# Gatwick Airport Northern Runway Project

Response to the Examining Authority's Written Questions –  
Historic Environment

Application Document Ref: 10.16

PINS Reference Number: TR020005

|          | FIGURE 7.6.2    | For ES issue |

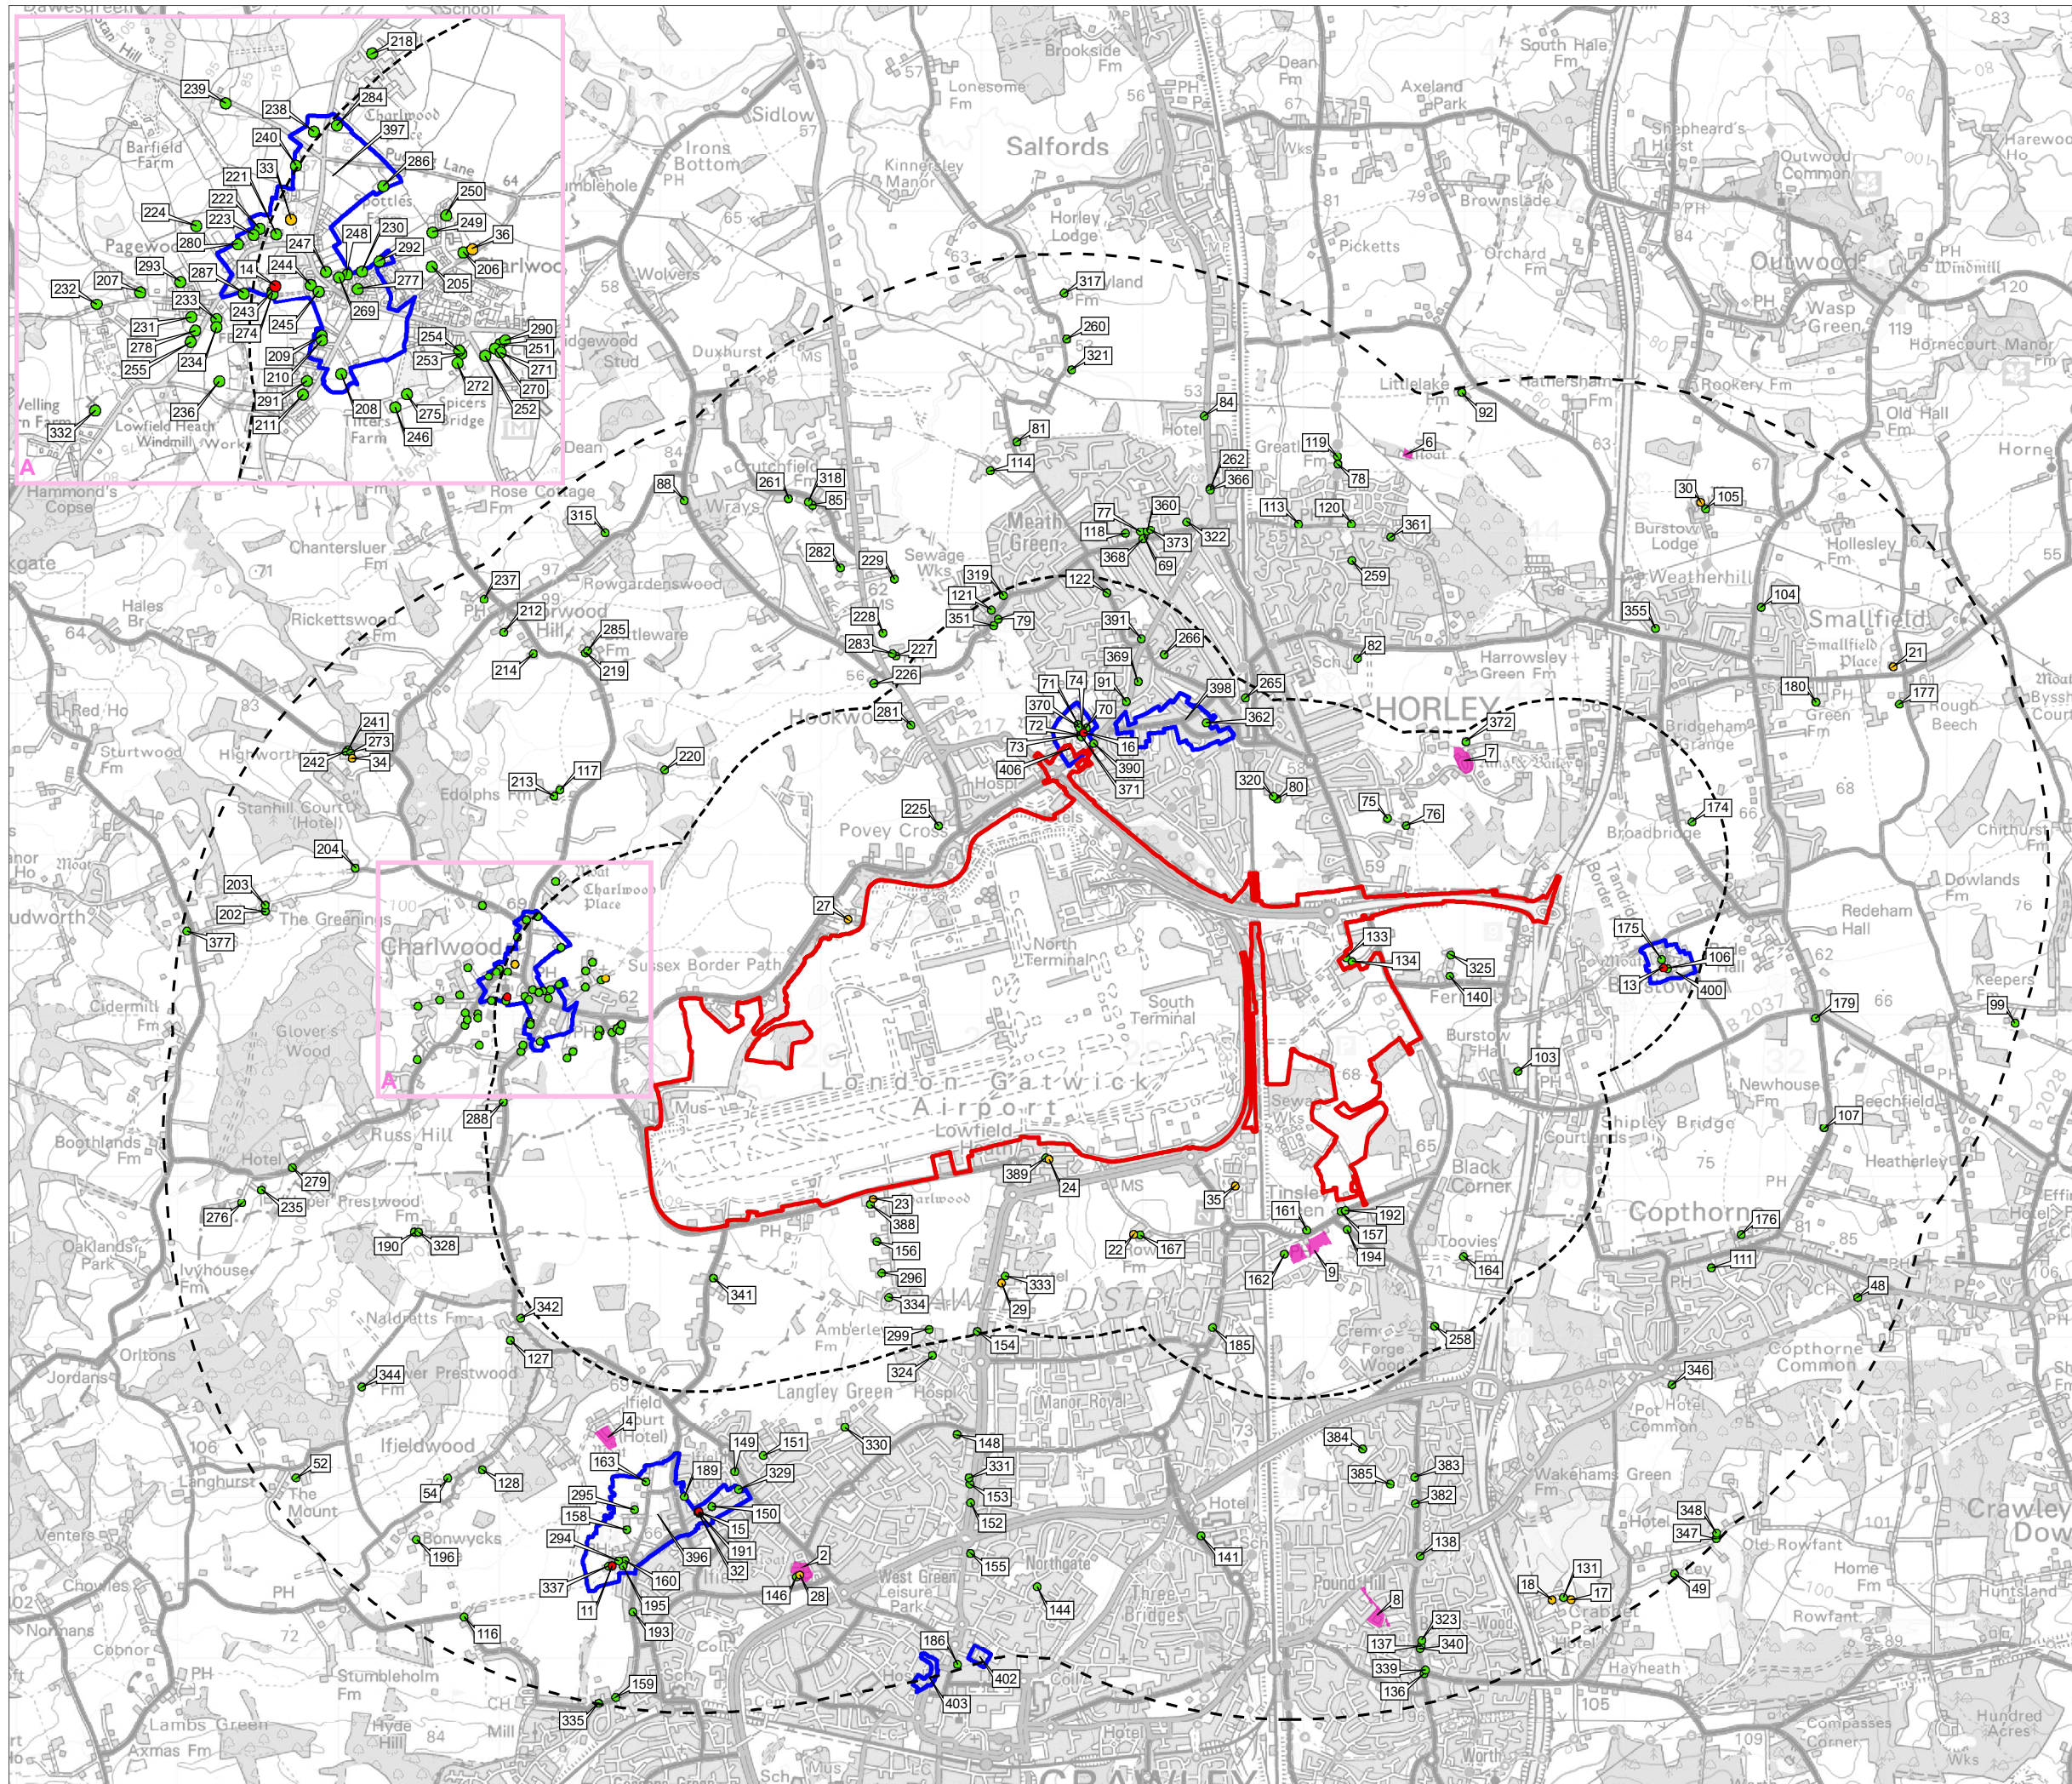
| HE.1.6 | The Applicant | <p><b>Burstow Conservation Area</b></p> <p><b>Provide further information about any effects on the setting of Burstow Conservation Area and the Grade I Church of St Bartholomew as a result of the Proposed Development.</b></p>  |

|        |               | <p>The location of the Conservation Area, the Zone of Theoretical Visibility and the noise change contour used in the assessment are shown within the <b>ES Historic Environment Figures [APP-054]</b> at Figures 7.6.2, Figure 7.6.3 and Figure 7.6.6 respectively. As the Conservation Area at Burstow is outside of the area of 1dB change of Leq contour it has not been included within the scope of the assessment.</p>   |
